Item No. **Report of the Head of Planning, Sport and Green Spaces**

Address 89 LONG LANE HILLINGDON

Development: Hip to Gable Extension, part two storey side/rear extension and single storey side/rear extension

LBH Ref Nos: **3432/APP/2014/2020**

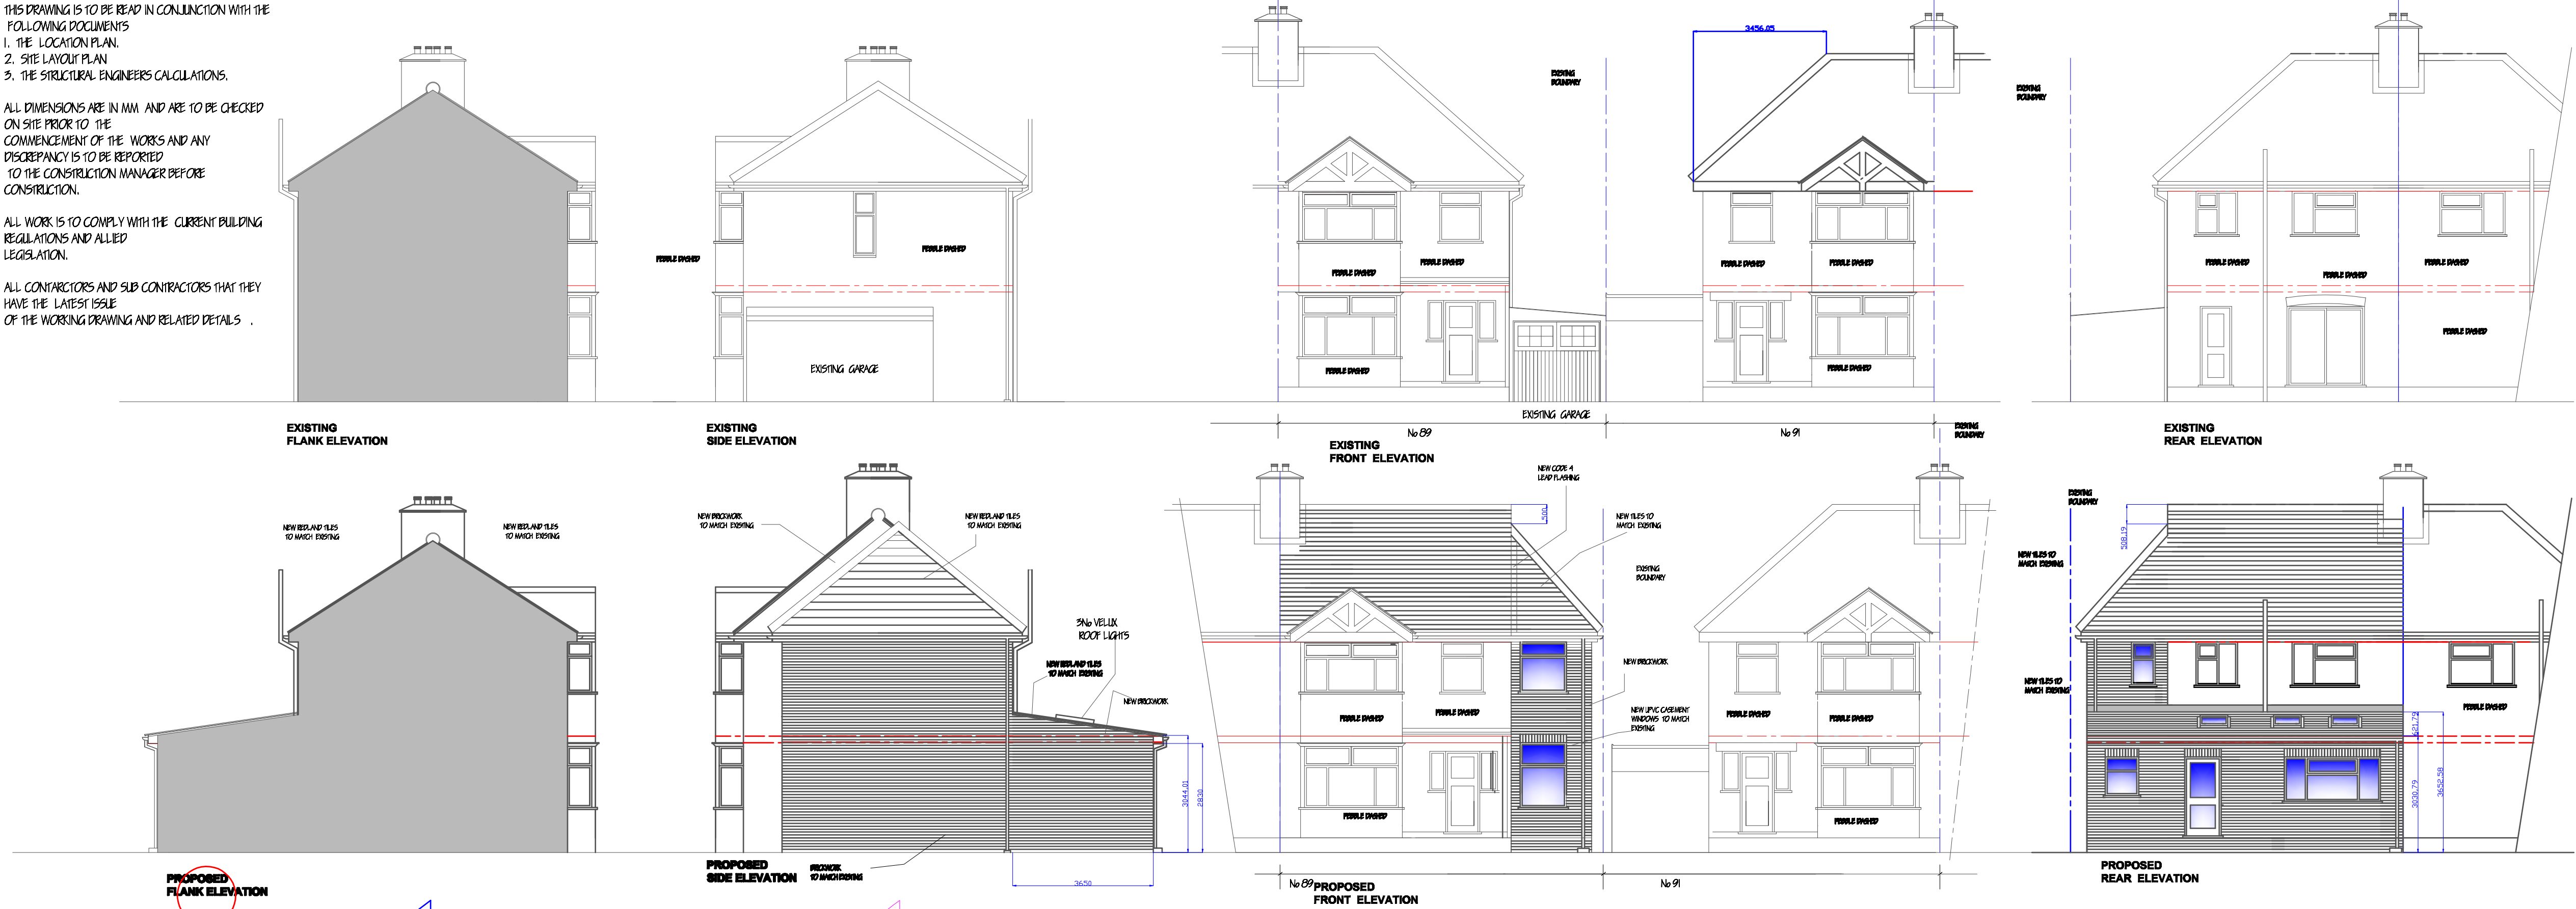
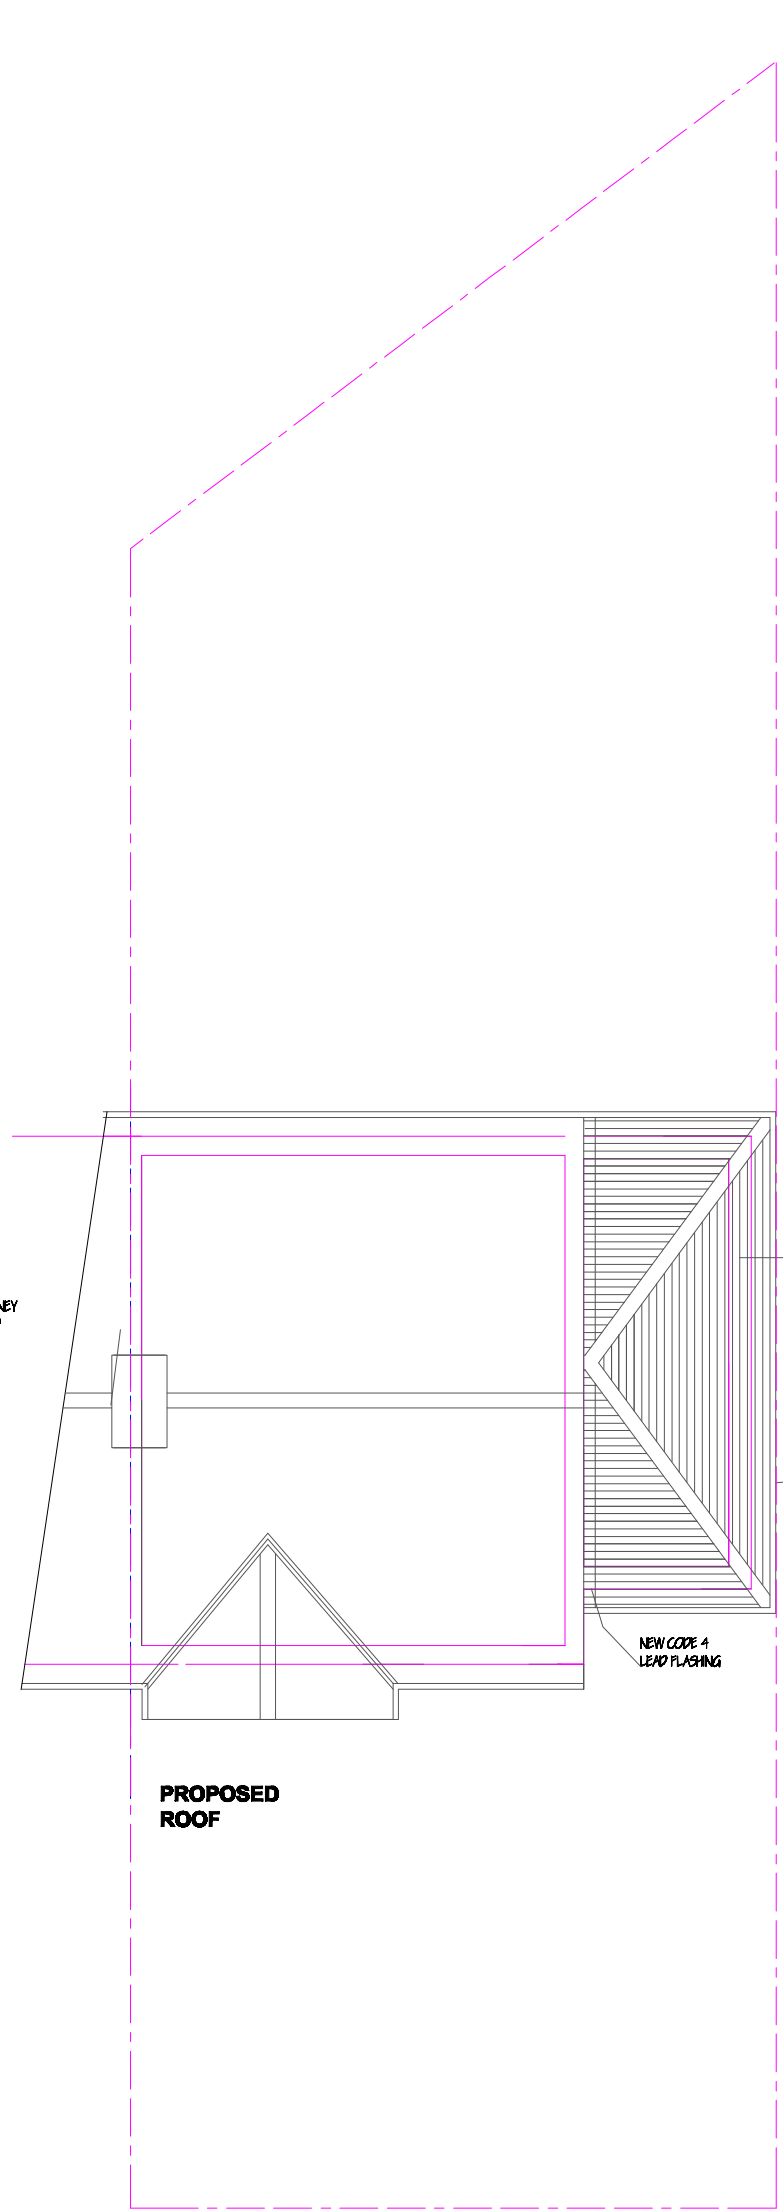
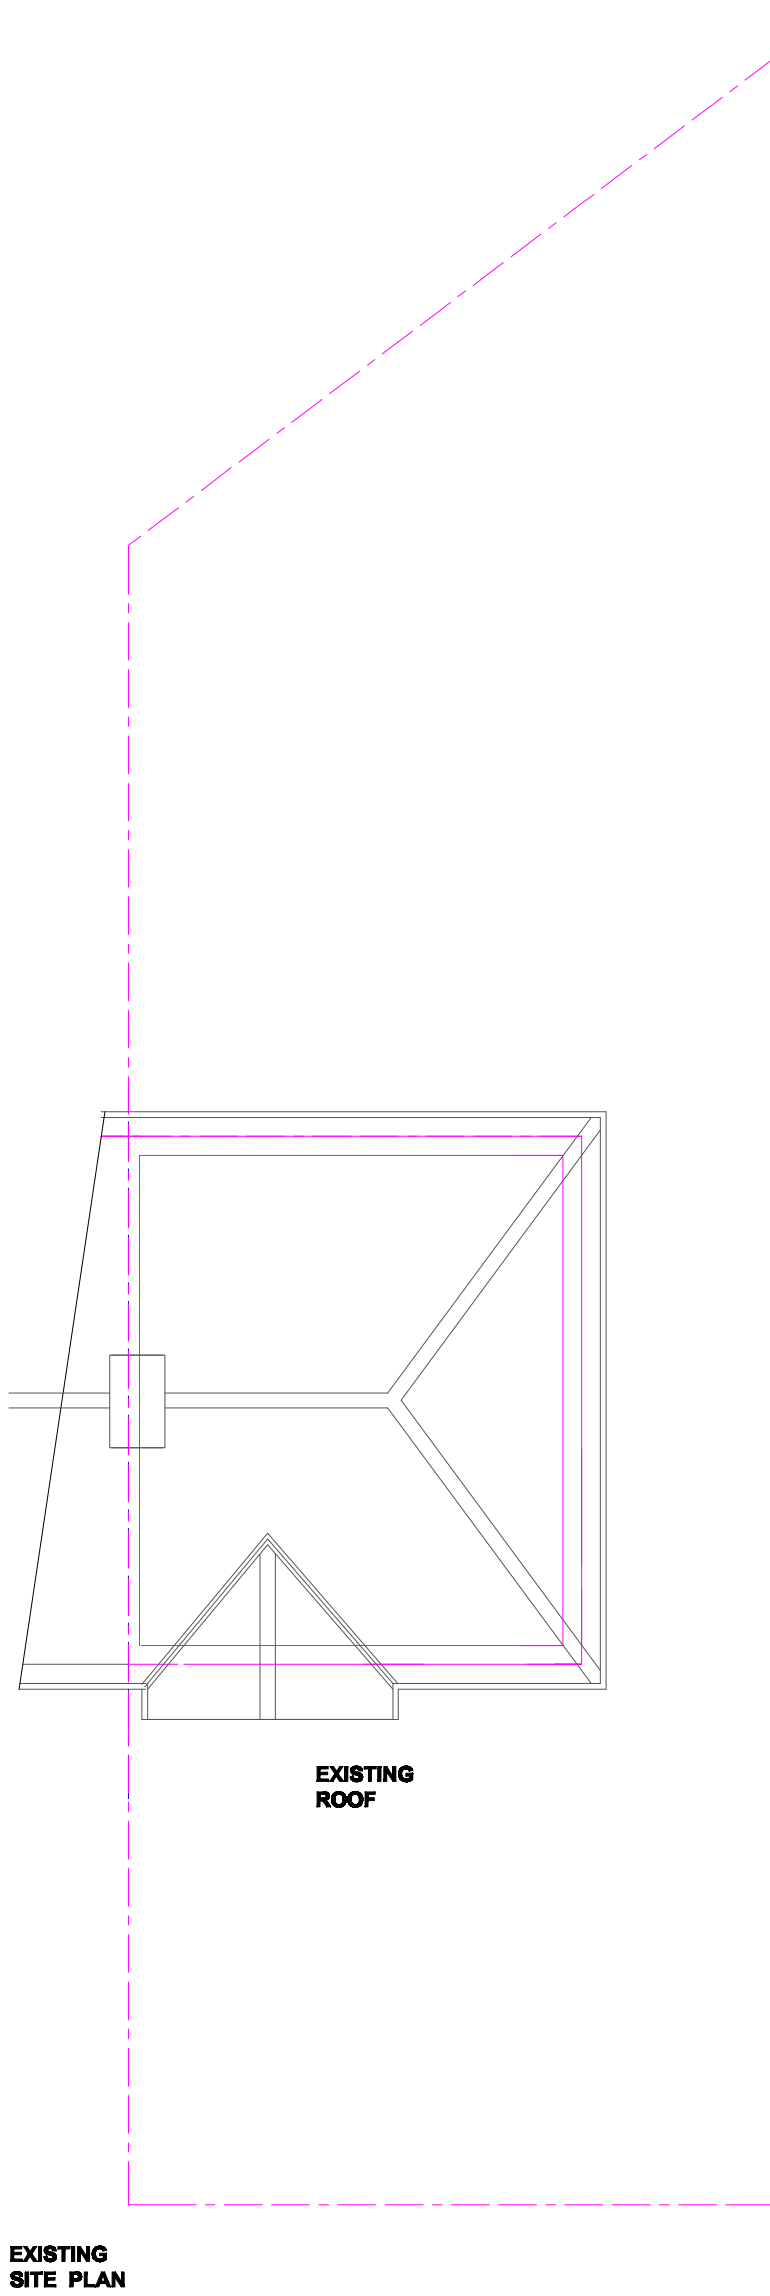
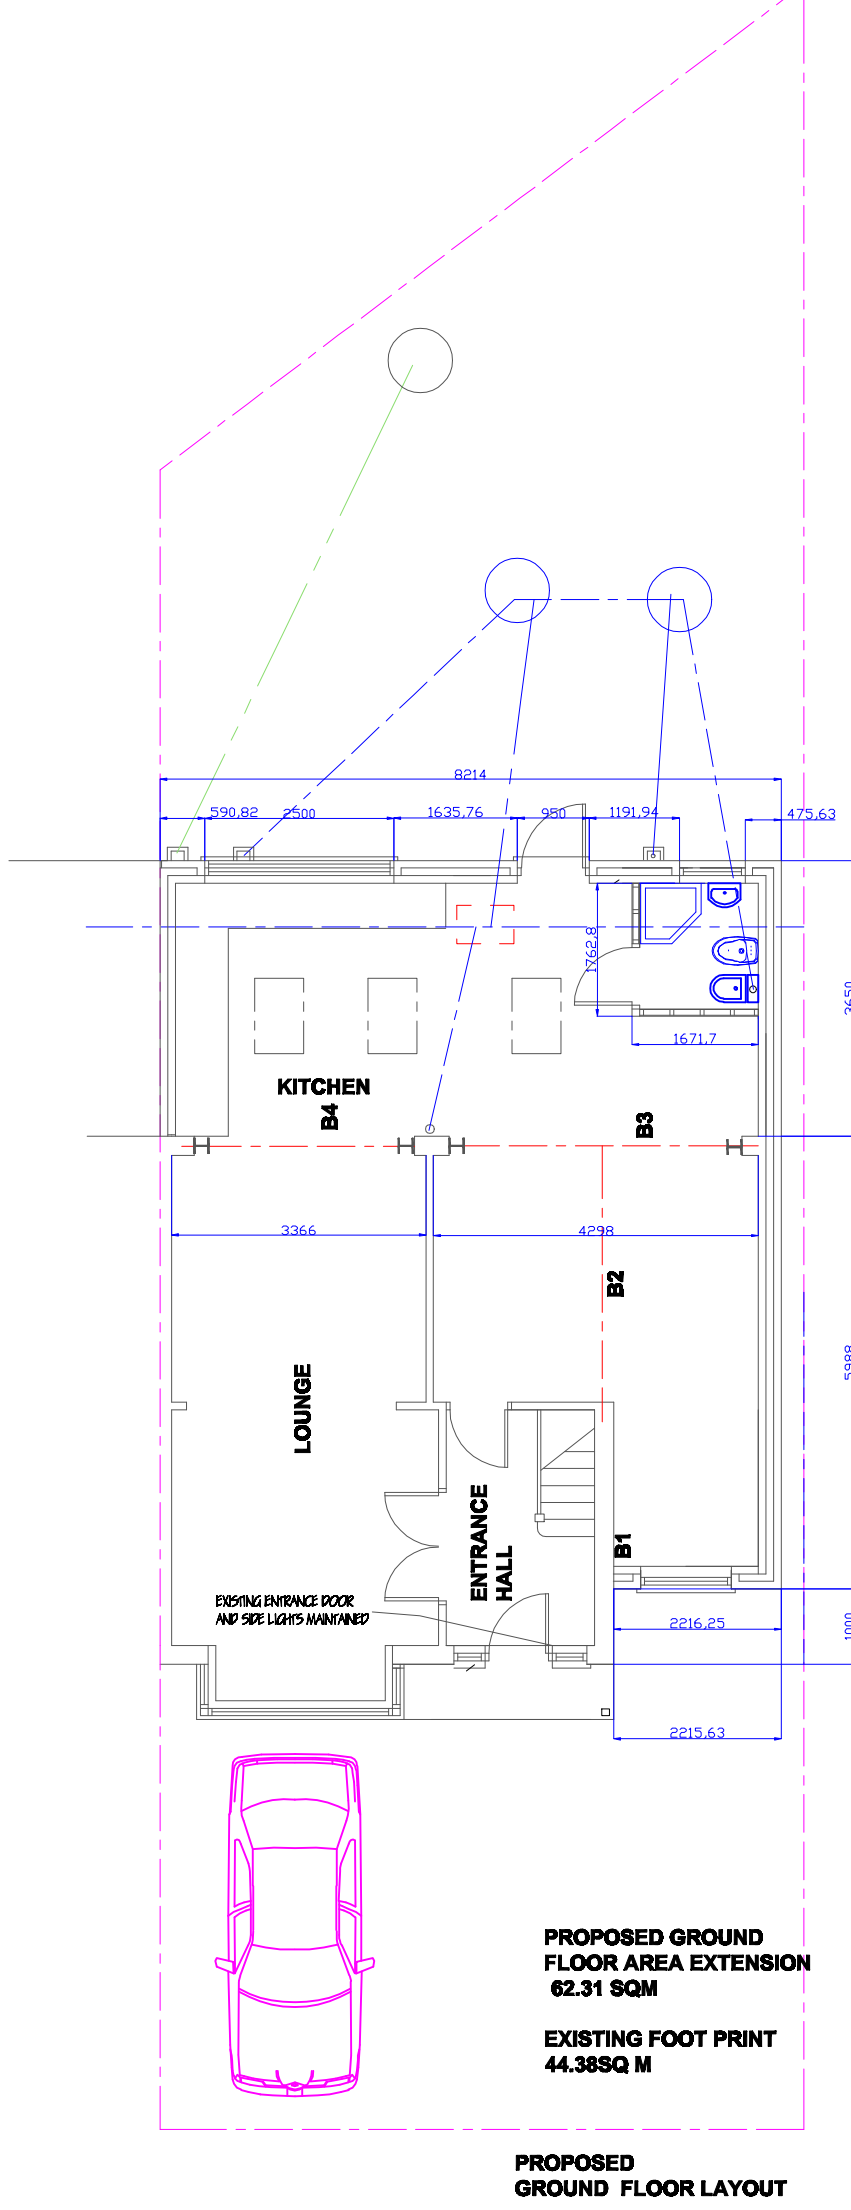
The proposed two storey side extension would not be any more than two thirds the width of the original house and would be set-back 1m behind the main front elevation of the house in accordance with this advice. However the proposal would not retain a gap of 1m to the side boundary and would result in the alteration of the main roof from a hip to a gable with a hipped roof to the extension. Even if the roof conversion is carried out as permitted development, the proposed hipped roof to the extension would be at odds with the gabled roof and would appear as an incongruous addition to the property. Moreover, the two storey side extension would only be 0.2m away from the site boundary and as a result would fail to preserve an adequate visual gap between it and the adjacent property. The two storey side extension is therefore contrary to Policy BE1 of the Hillingdon Local Plan: Part One - Strategic Policies (November 2012) and policies BE13 and BE15 of the Hillingdon Local Plan: Part Two - Saved UDP Policies (November 2012).

Paragraph 3.3 of the HDAS states that single storey rear extensions proposed on semi-detached houses with a plot measuring 5m wide or more should be no more than 3.6m deep. Likewise paragraph 3.7 states that such extensions should be no more than 3.4m in height. This is to ensure that the extension appears subordinate to the main house. The proposal marginally exceeds this advice, but is considered, on balance, to appear subordinate to the host dwelling. It is noted that the rear roof has been reduced in height from that which was previously refused to ensure the ridge sits well below the cill of the first floor windows above.

There is a first floor side facing window at No. 91 which would be affected by the proposed two storey side extension, however, as it serves a landing it is therefore considered that the proposed two storey side extension would not cause harm to the amenity of the residents at that property.

However, Policy BE23 of the Local Plan states that new residential buildings or extensions should provide or maintain external amenity space which is sufficient to protect the amenity of the occupants of the proposed as well as surrounding buildings which is usable in terms of its shape and siting. The supporting text relating to this policy emphasises the importance of protecting private amenity space and considers it a key feature of protecting residential amenity. Paragraph 3.13 of the HDAS recommends that a four bedroom house should retain at least 100sq.m of usable garden space. The proposed single storey rear extension means that only 72sq.m of rear garden space would be retained for the site,

which would be substantially below that required and contrary to policy BE23.

The proposed hip to gable extension of the host dwelling and the size, scale, bulk and design of the two storey side extension would be detrimental to the character and appearance of the original house, would result in a visual imbalance of this pair of semi-detached properties, 87 and 89 Long Lane and would be detrimental to the visual amenity of the street scene and the wider area generally. The proposal is therefore contrary to Policy BE1 of the Hillingdon Local Plan: Part One - Strategic Policies (November 2012), Policies BE13, BE15 and BE19 of the Hillingdon Local Plan: Part Two - Saved UDP Policies (November 2012) and the adopted Supplementary Planning Document HDAS: Residential Extensions.

The proposed two storey side extension by reason of its siting, size, scale, design and proximity to the side boundary, would result in a closing of the visually open gap between it and the neighbouring property, 91 Long Lane, giving rise to a cramped form of development, which would be detrimental to the visual amenities of the street scene and the surrounding area generally. The proposal is therefore contrary to Policy BE1 of the Hillingdon Local Plan: Part One - Strategic Policies (November 2012), Policies BE13, BE15, BE19 and BE22 of the Hillingdon Local Plan: Part Two - Saved UDP Policies (November 2012) and the adopted Supplementary Planning Document HDAS: Residential Extensions.

The proposed single storey rear extension would, by virtue of its failure to maintain an adequate amount of private usable external amenity space for the occupiers of the existing property, result in an over-development of the site detrimental to the residential amenity of existing and future occupiers. The proposal is therefore contrary to Policies BE19 and BE23 of the Hillingdon Local Plan: Part Two - Saved UDP Policies (November 2012) and the adopted Supplementary Planning Document HDAS: Residential Extensions.
